Application for a non-material amendment following a grant of planning permission.
Town and Country Planning Act 1990

Demolition of garage and erection of new two storey chalet style extension and roof extension to existing bungalow.

R/19/14

Omit small gable roofs over south facing bay windows.

Proposed South Elevation (front)
Scale 1:100 @ A1

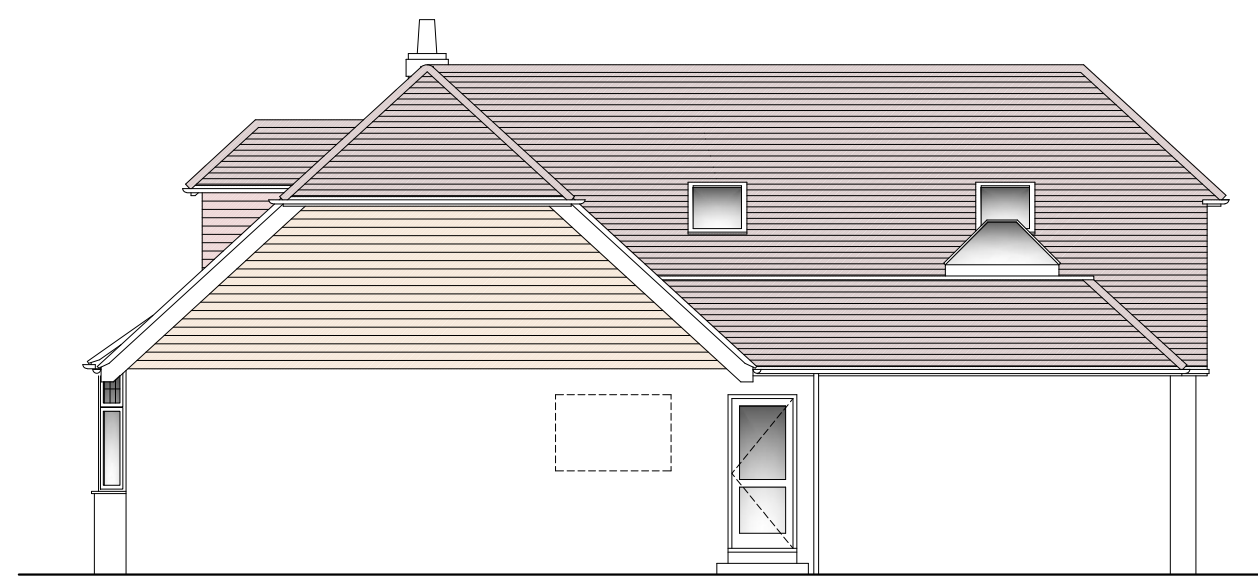
The builder is having trouble making the small gable roofs over the bay windows fit and therefore we propose a simpler solution to overcome the site constraints.
